RE: BMW House, Chandlers Garage Ltd, Water Lane , Angmering BN16 4HE

Thank you for your correspondence of 26th April 2019 advising me of 'Demolition of existing buildings (car show room, workshops and Phares Courtledge) and erection of 19 dwellings, a convenience store, a community building, public toilets and associated car parking and landscaping - This application affects the character and appearance of the Angmering Conservation Area' at the above location, for which you seek advice from a crime prevention viewpoint.

Plots 12-16 Convenience Store Building and Parish Council building.

DRAWING TITLE
Plots 12-16 + Retail,
Apartments & Co-Op,
Elevations

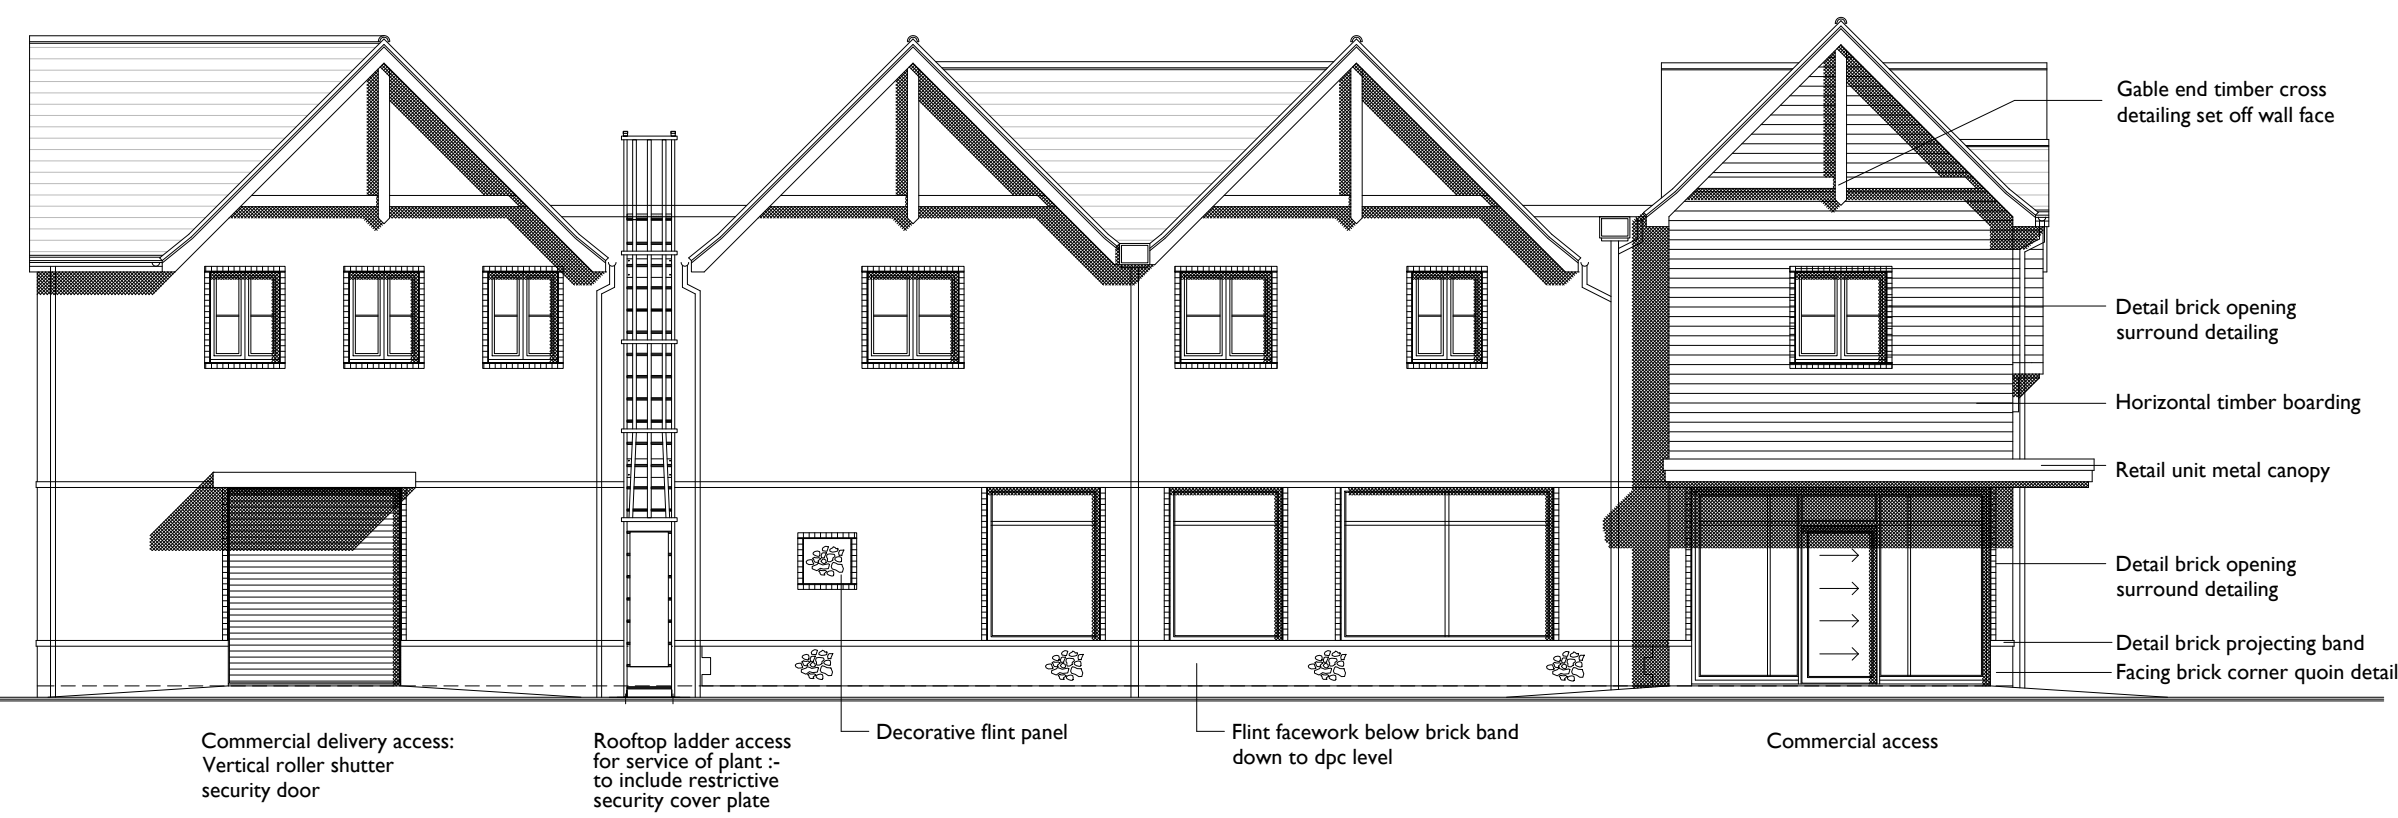
It is important that the door set apertures for all the ground floor doors are protected. There is an expectation that security will be required to meet the following minimum standards when the buildings are unoccupied. PAS24:2016, LPS1175: Issue 7 SR2, STS201, and STS202: Issue 3 BR2. (Paragraph 56.1 and 56.2 of SBD Commercial Developments 2015 refer).

Likewise all ground floor and easily accessible windows should meet the specifications recommended in (paragraph 62.1), with applicable glazing meeting (paragraph 60.1).

Any fire doors should be devoid of external door furniture and be fitted with an alarm with remote access to enable staff to be alerted that the door has been opened. Signage adjacent to the door is to inform users of the consequences of misuse.

If roller shutters are fitted to the store loading bay, I recommend they meet a minimum standard of LPS1175: Issue 7 SR1 or STS202 Issue 3 BR1.

SBD Commercial Developments 2015 Paragraph's 35.1 to 35.3 recommends that external staircases should be avoided. The roof access ladder must be secured out of reach to prevent unauthorised access and secured to prevent climbing. I recommend suitable padlocks to a minimum standard of Sold Secure 'Silver' standard are used to secure the upper drop down section.

In regard to the external cable and service riser located on the South East wall of the convenience store building, (Chapter 30) of SBD Commercial Document 2015 provides recommendations regarding security for essential services.

Paragraph 56.11 provides advice regarding recessed doorways which should be avoided where possible as they provide opportunities for crime and anti-social behaviour, graffiti arson and burglary.
